Our Ref: 2022/054180
File No: R/2017/25/I
Your Ref: SSD-8925-MOD-6

Rodger Roppolo
Senior Planning Officer – Key Sites Assessments
Department of Planning, Industry and Environment

The New Sydney Fish Market – SSD 8925 MOD 6 – Temporary construction site accommodation – Advice on Response to Submissions

**Figure 3 |** Site plan (source: Applicant's RTS)

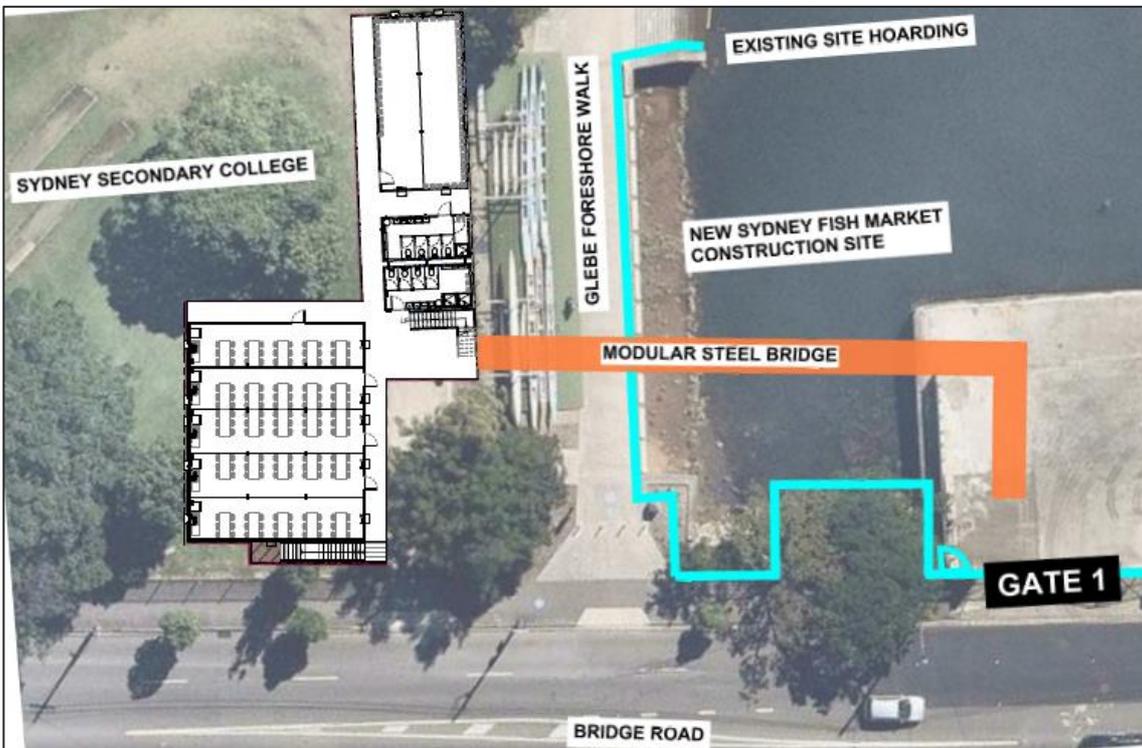
- The design of temporary structures should be amended to be slightly setback from the trees canopy to reduce the level of pruning specified to tree T4.

- All plans are to be updated to show the TPZ, SRZ and existing canopy spread of exiting street trees.
- Reference should be made to the City's '*Tree Guidelines for Pruning, Reporting and Using an Arborist*' for guidance on information that must be provided in an Arboricultural Impact Assessment Report, including tree pruning specification and exploratory root investigation. More information can be found at <https://www.cityofsydney.nsw.gov.au/property-tree-maintenance/apply-prune-remove-tree>

**Figure 4 | Proposed tree removal – T8** (source: Applicant's RTS)

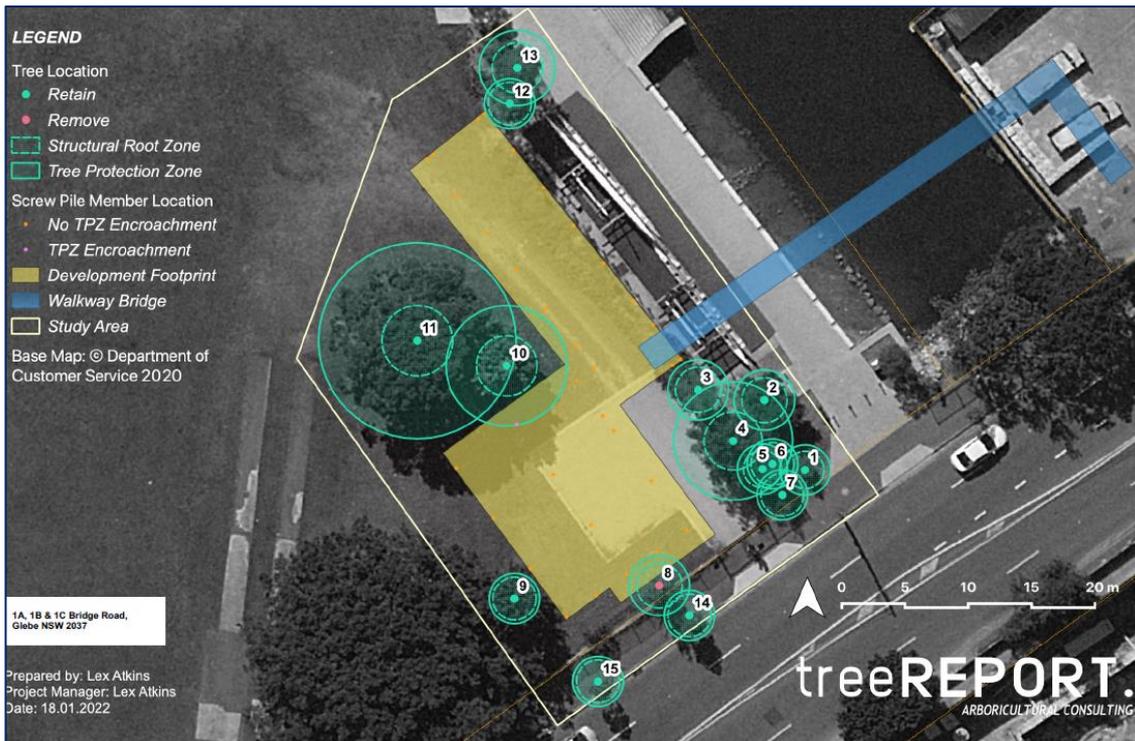
Overall, the City is generally supportive of the amendments to retain and prune trees T3 and T10, however, the proposed removal of tree T8 and extensive pruning to tree T4 to facilitate temporary works is still concerning. The following recommendations are made:

- To retain tree T8, the proposed sewer connection should be relocated outside the Tree Protection Zone (TPZ) of all existing trees. Alternative installation methods for services, such as directional boring/drilling, or redirection of services shall be employed where large woody roots greater than 30mm diameter are encountered during the installation of any services adjacent to the specified TPZ.
